# CITY OF ALBUQUERQUE

**Re: Grace Church Family,  
1700 57<sup>th</sup> St. NW, 87105  
Request for Certificate of Occupancy  
Transportation Development Final Inspection  
Engineer's/Architect's Stamp dated 2-28-18(DRB) (H11D027)  
Certification dated 5-29-19**

**TITLE: SITE DEVELOPEMENT PLAN**

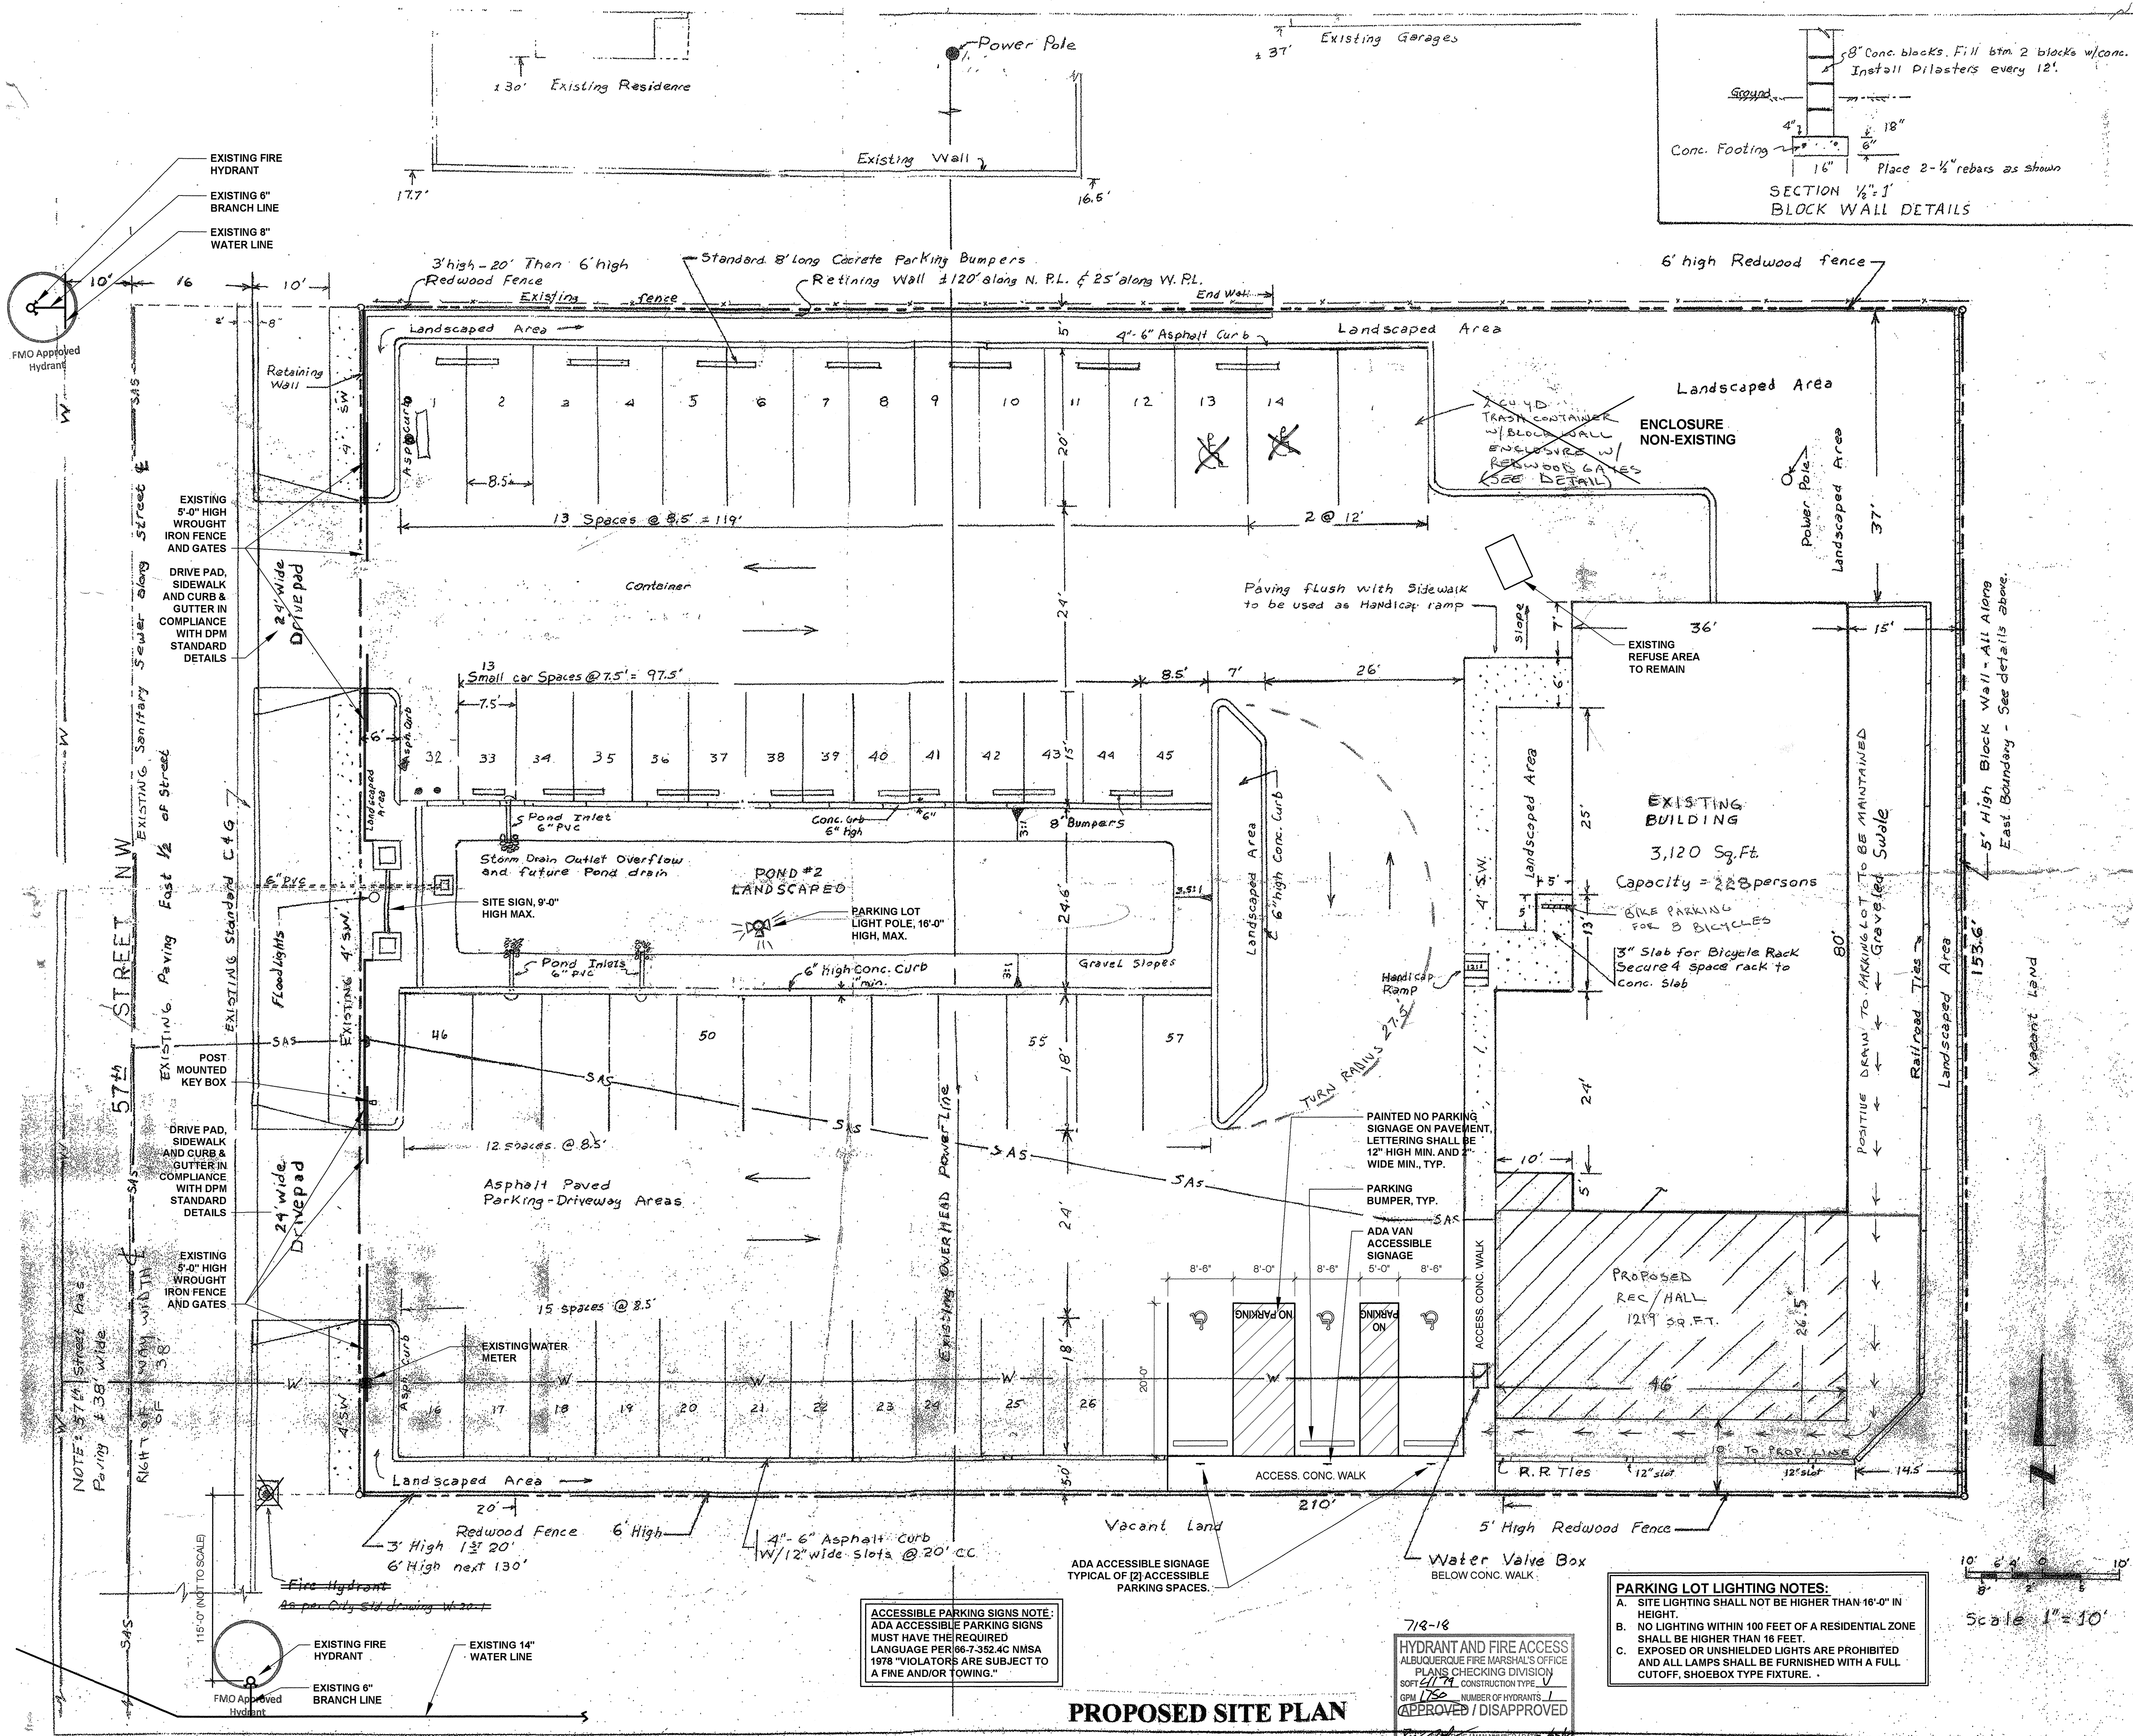
- Gate was locked. Please leave number of contact to open gate when re-submitting for CO.
- Wheel stops appear to have rebar sticking out 3 inches above top.
- Please correct the ADA signs to current standards
- Please add No Parking to access aisle.
- Please add bike rack per approved plan.
